# ***City of Albuquerque***

**March 13, 1996**

**RE: GRADING & DRAINAGE PLAN FOR NEW VISTAS UNIT 1 (B-13/D10)  
ENGINEER'S STAMP DATED 08-26-95**

A SECTION Y-Y

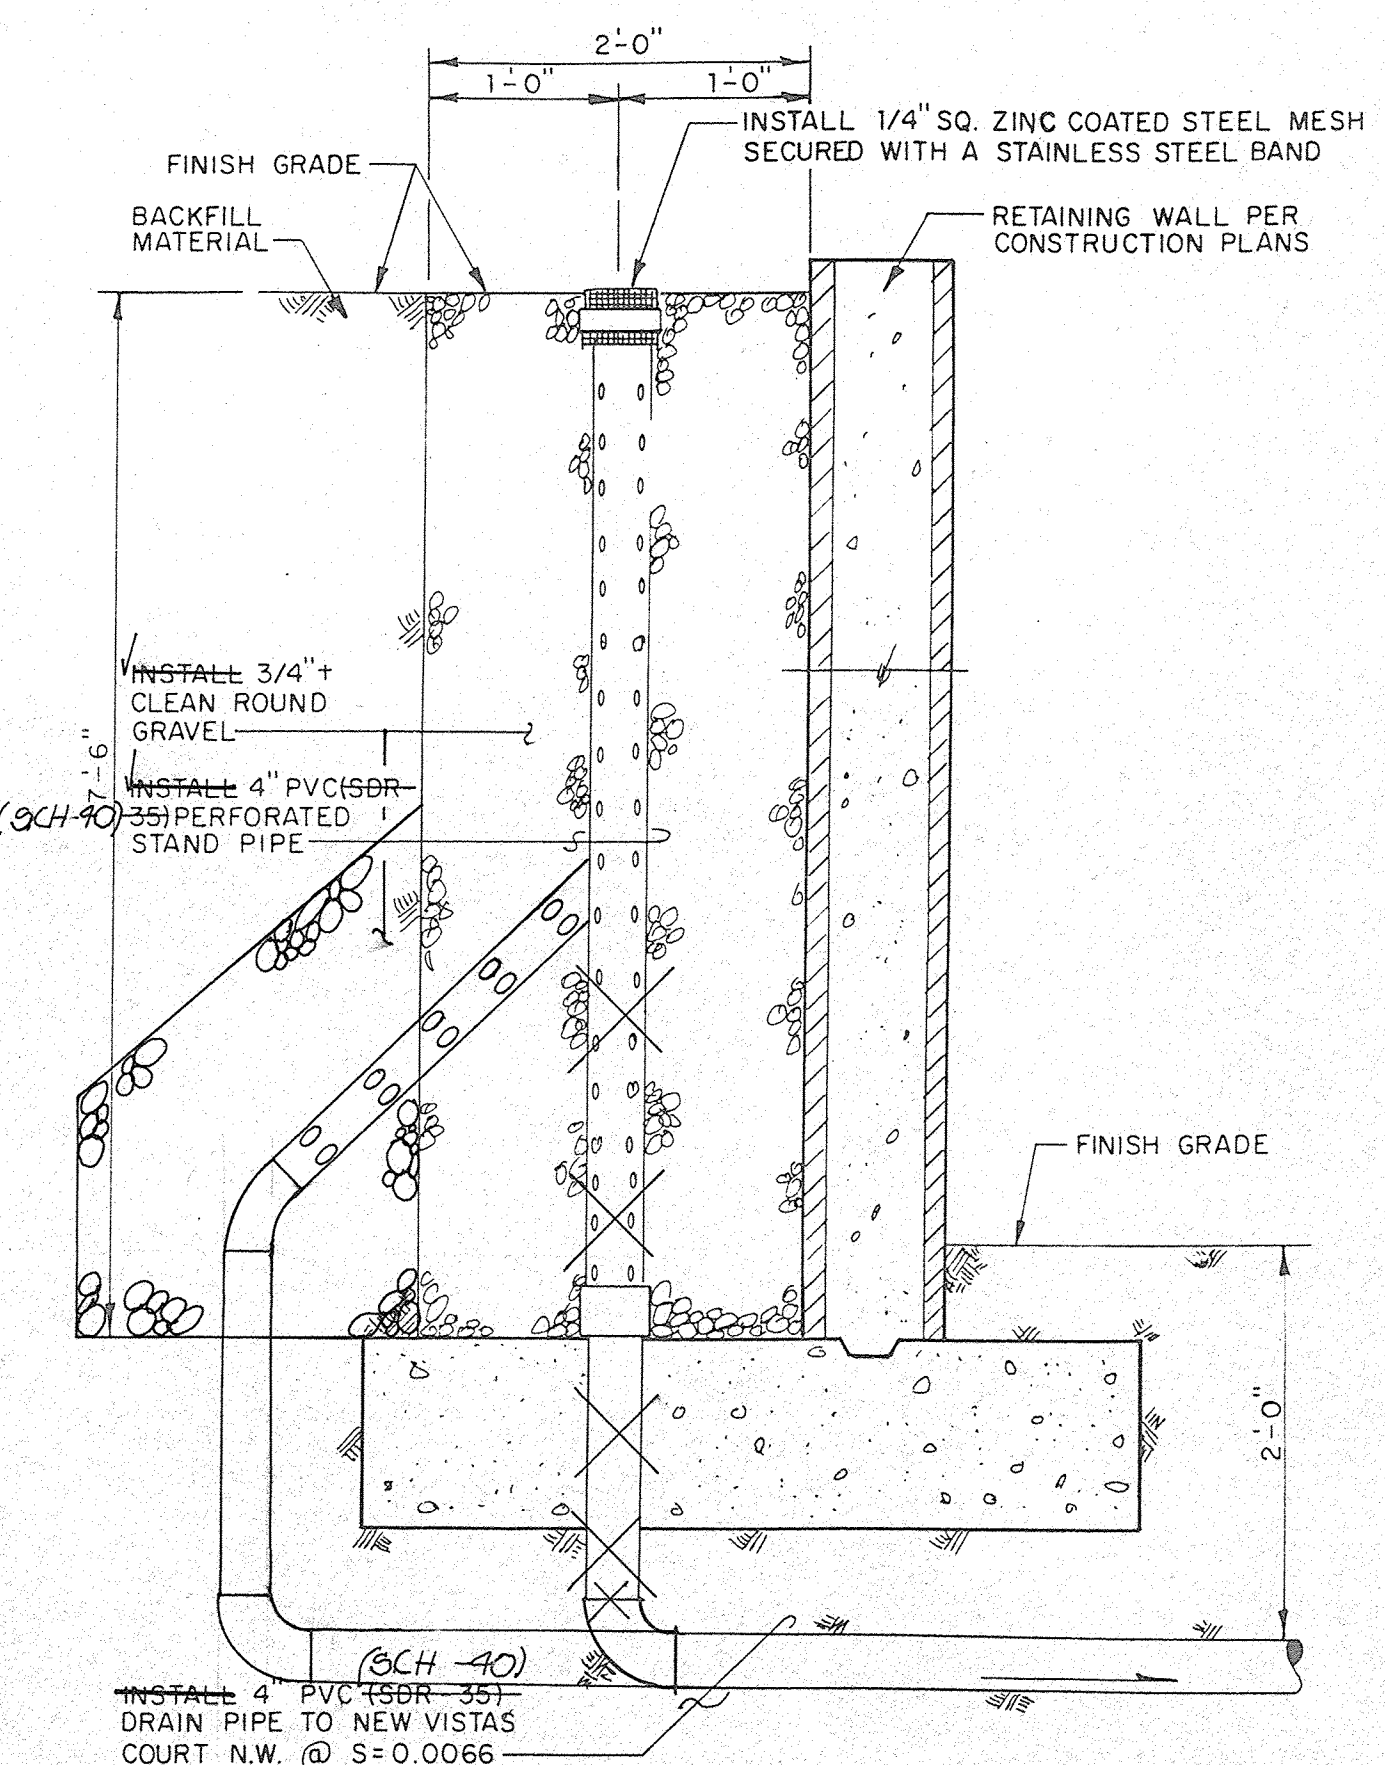
Furthermore, City Hydrology is concerned that the mesh drain cover shown on section Y-Y will clog easily. A beehive inlet would be less likely to clog. If the drain does clog it will create an impressive waterfall.
